Project:  
**415 CUMBERLAND AVENUE**  
 PORTLAND, MAINE

Scale: 1/8" = 1'-0"  
 Date: 12 April 2018  
**ELEVATIONS**

**A2.01**

ELEVATIONS

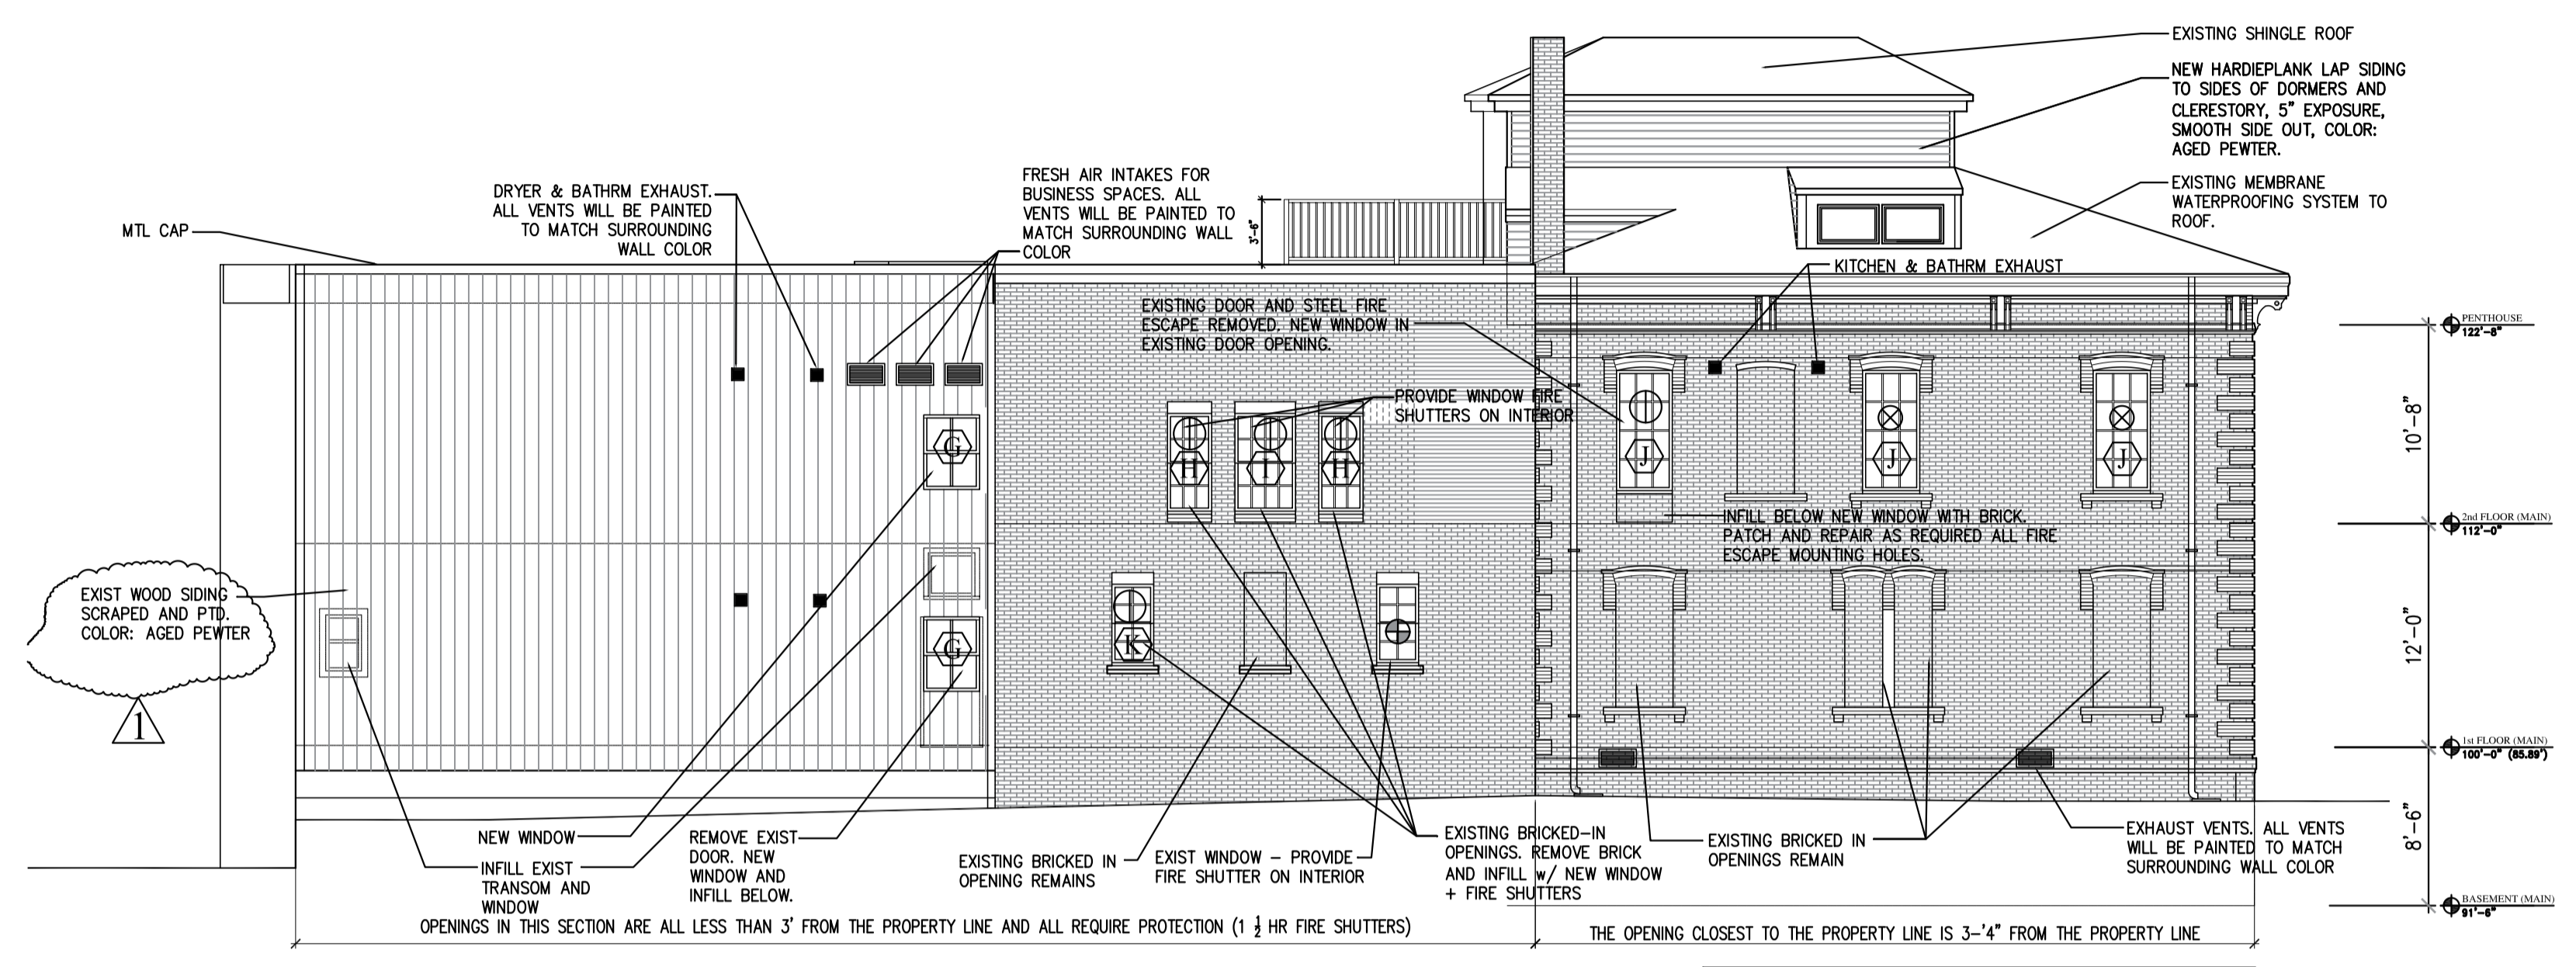
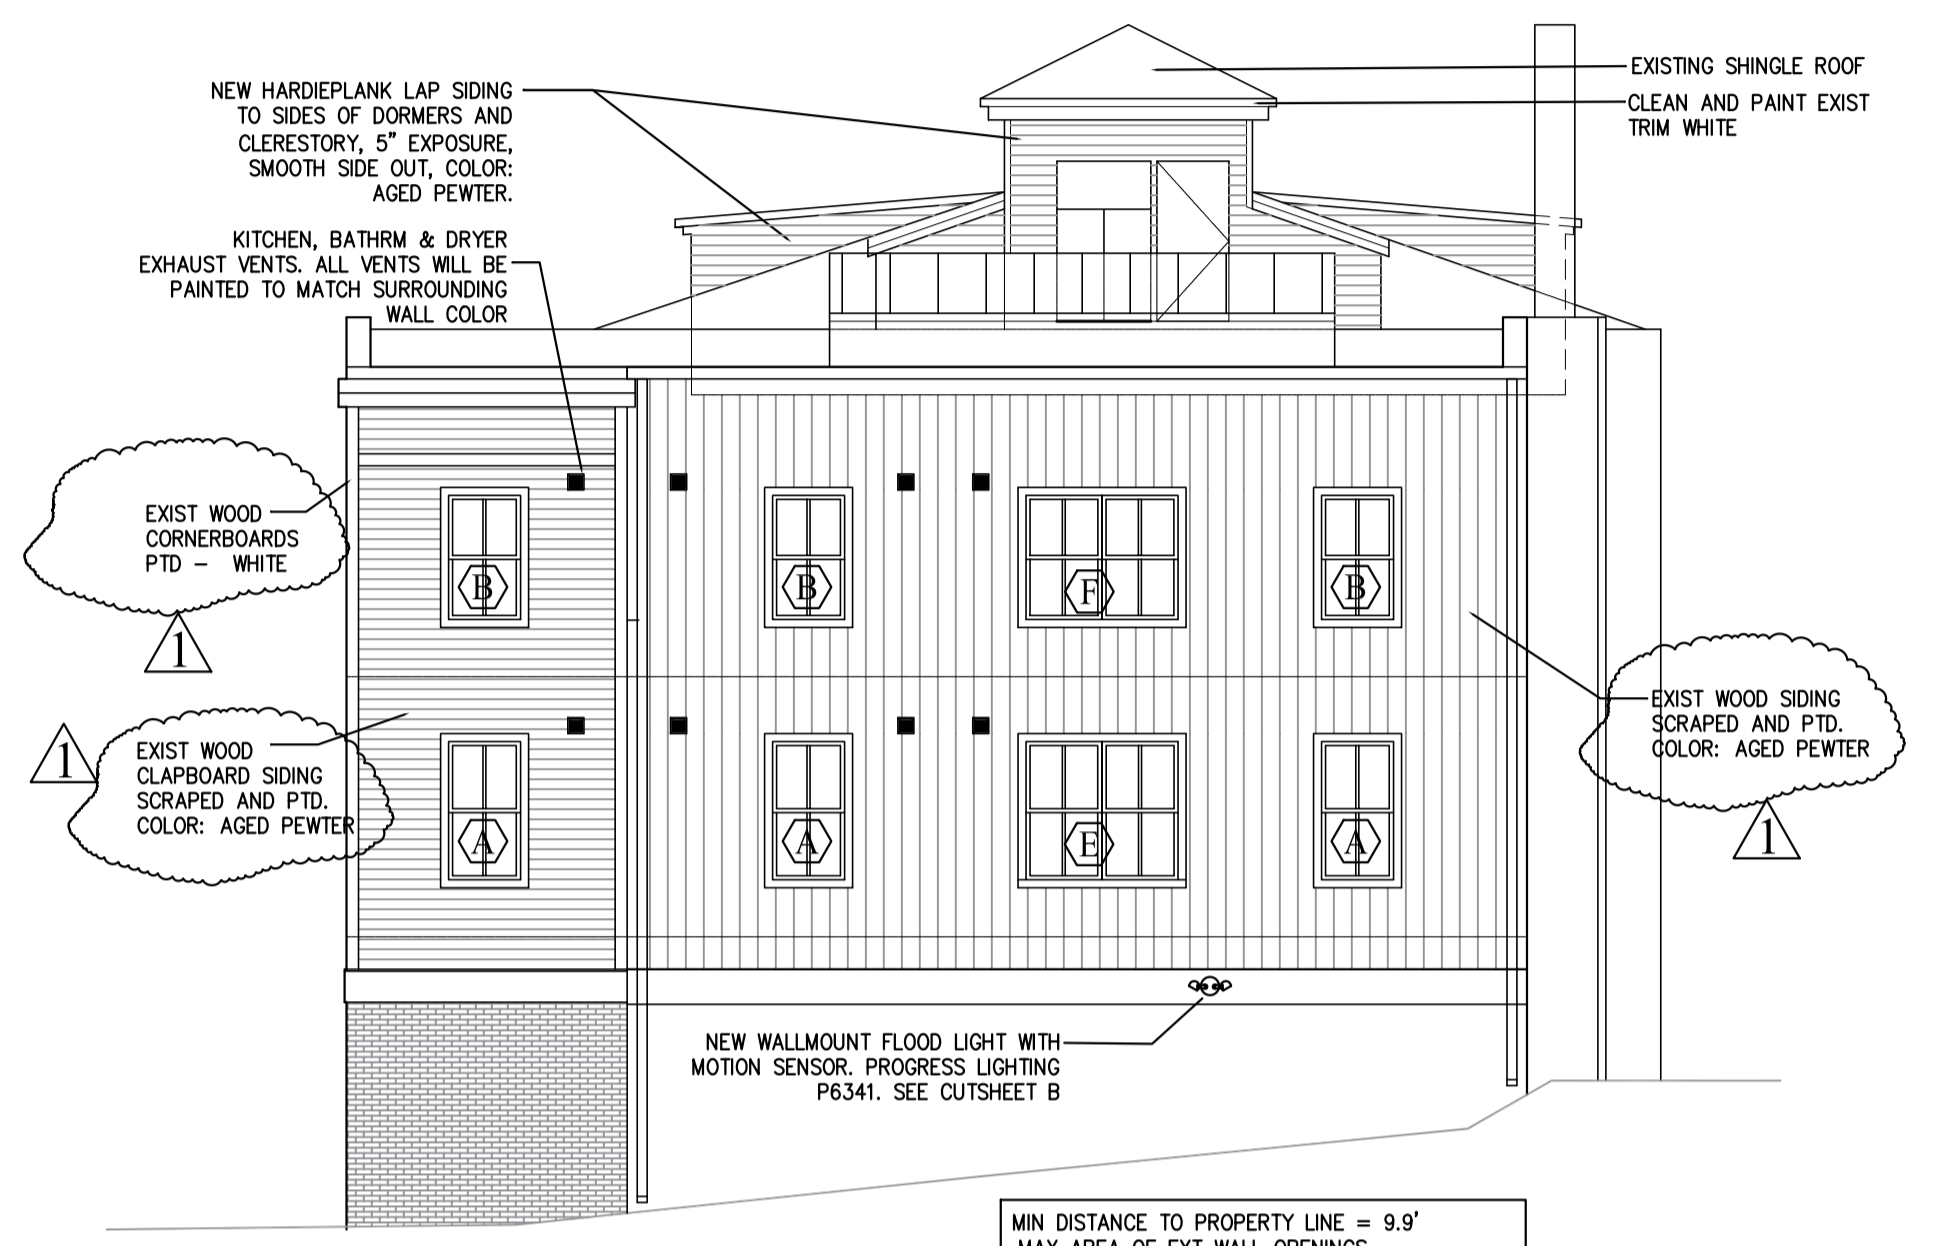
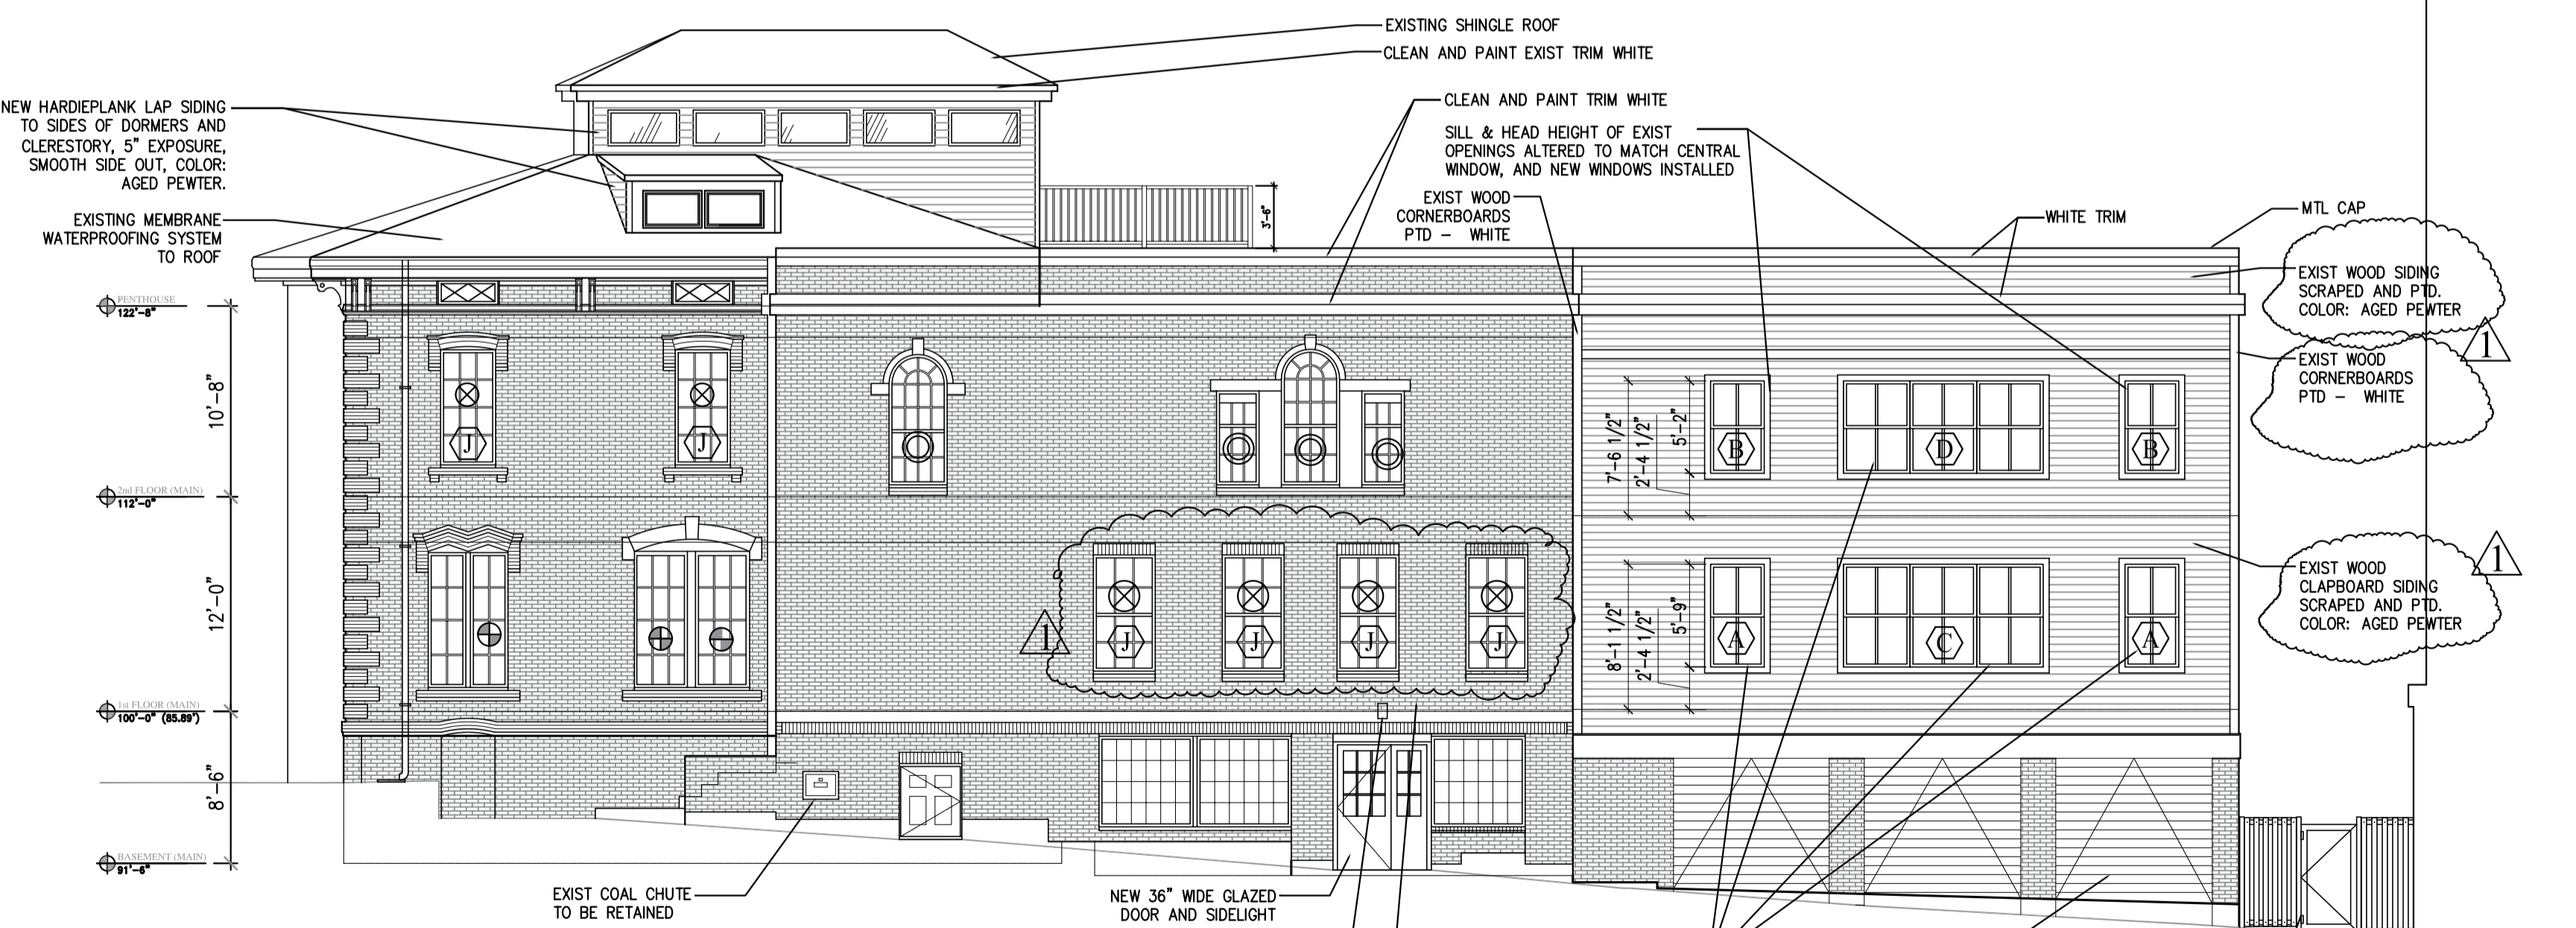
: SHOULD BE ALUMINUM CLAD WINDOW, ALUMINUM FINISHED TO MATCH SIDING (CLOSE IN COLOR).  
 (x 12) REMOVE GRILLE/GRIDS (MAKE 1/1) OR CHOOSE PRODUCT WITH EXTERIOR SIMULATED DIVIDED LITES + SPACERS, GLASS INTERIOR.

: VINYL WINDOW ACCEPTABLE, BUT REMOVE GRILLE/GRID BETWEEN THE GLASS OR CHOOSE PRODUCT WITH EXTERIOR SIMULATED DIVIDED LITES + GLASS INTERIOR SPACERS.
